## DECISION DELEGATED TO HEAD OF PLANNING

**Application No:** H06-0303-25      **Applicant:** Mr & Mrs D Hart  
**Proposal:** Proposed garage with storage above  
**Location:** Norwood House Station Road Gedney  
**Terminal Date:** 14th July 2025

This is a householder application seeking permission for a proposed garage with storage above at Norwood House, Station Road, Gedney.

## SOUTH ELEVATION

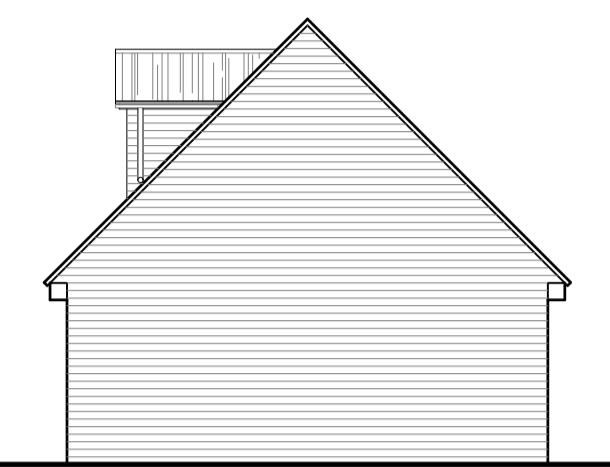
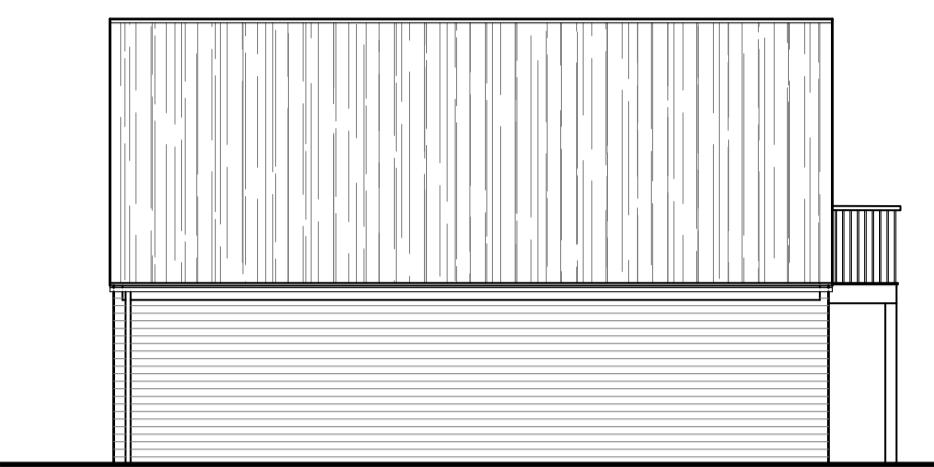
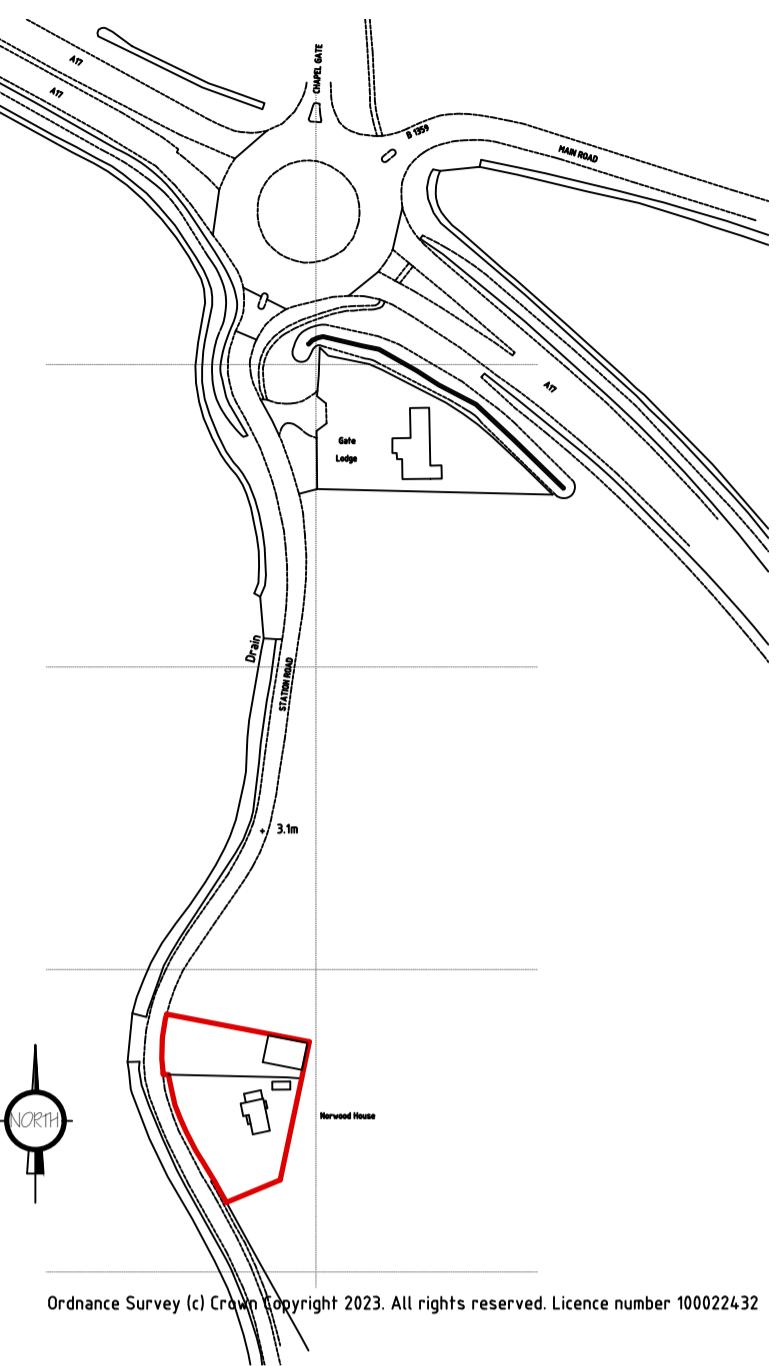
Previously, the height sat around 5800mm and featured large dormer windows and an external stair case. Given the siting, openness, scale and design, there were concerns over the visibility of the garage when approaching the site from the main road.

The amended scheme sees the height reduced to 5300mm and both the dormer windows and external stair case removed. Not only does this allow the garage to appear more subservient and domestic in appearance, it also ensures that the proposal has been reduced to appear more suitable and acceptable in this area.

# SITE PLAN 1:500

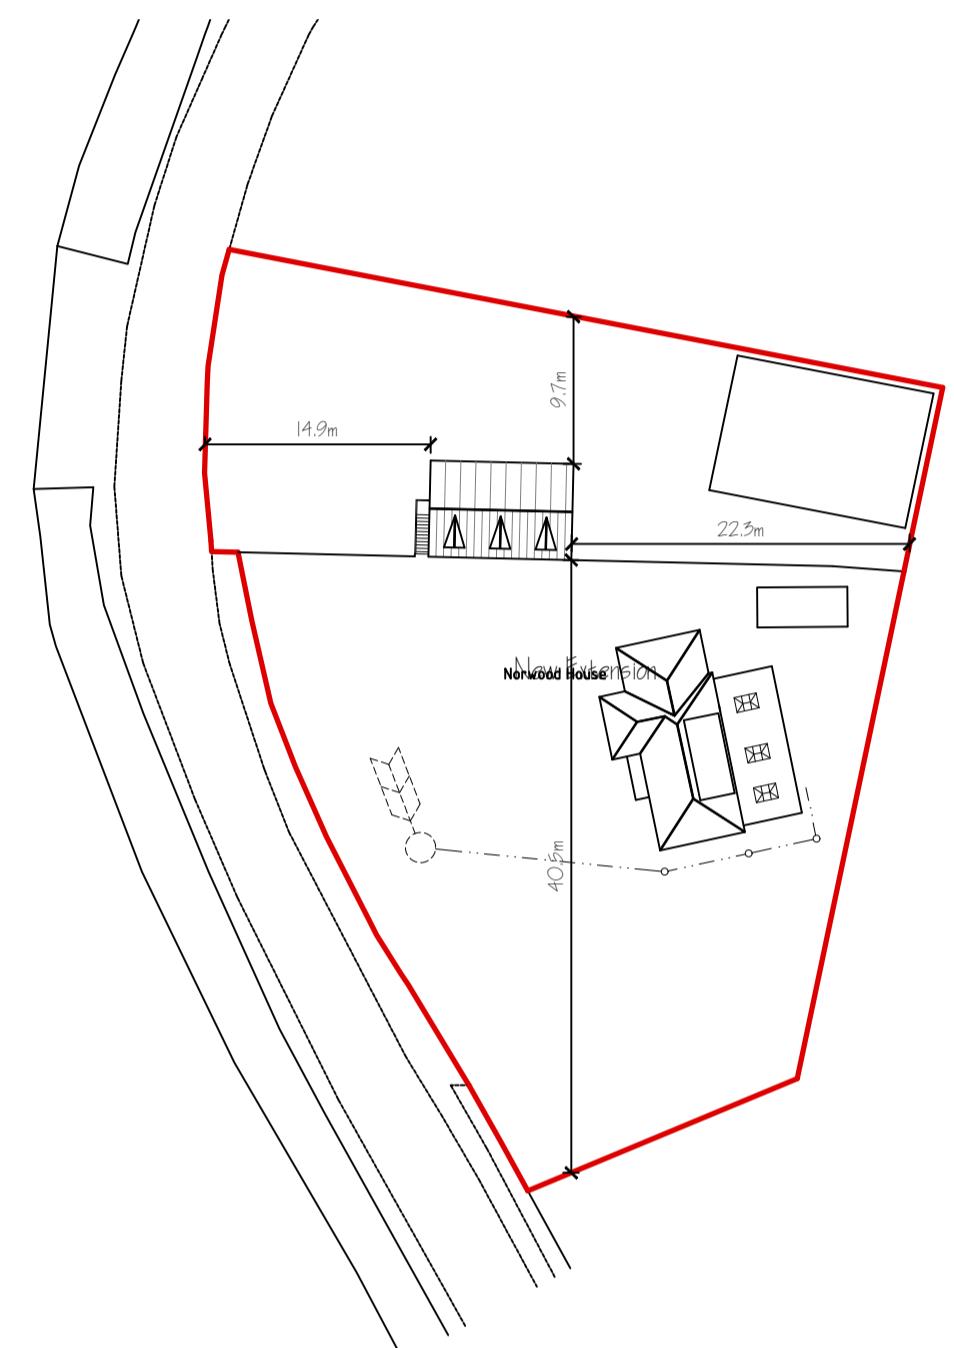
To further benefit the proposal, a new 1.8m high laurel hedge has been proposed along the northern boundary to the site. Although this is only 1.8m in height, it would reduce the visibility of the garage in some capacity and partly conceal it from view when approaching. Due to the layout of the site, the garage has limited places where it could be located making it only sufficient in front of the house. Despite this, it should not result in any unacceptable harm particularly due to properties further down the road featuring building which are clearly visible from the highway along Station Road.
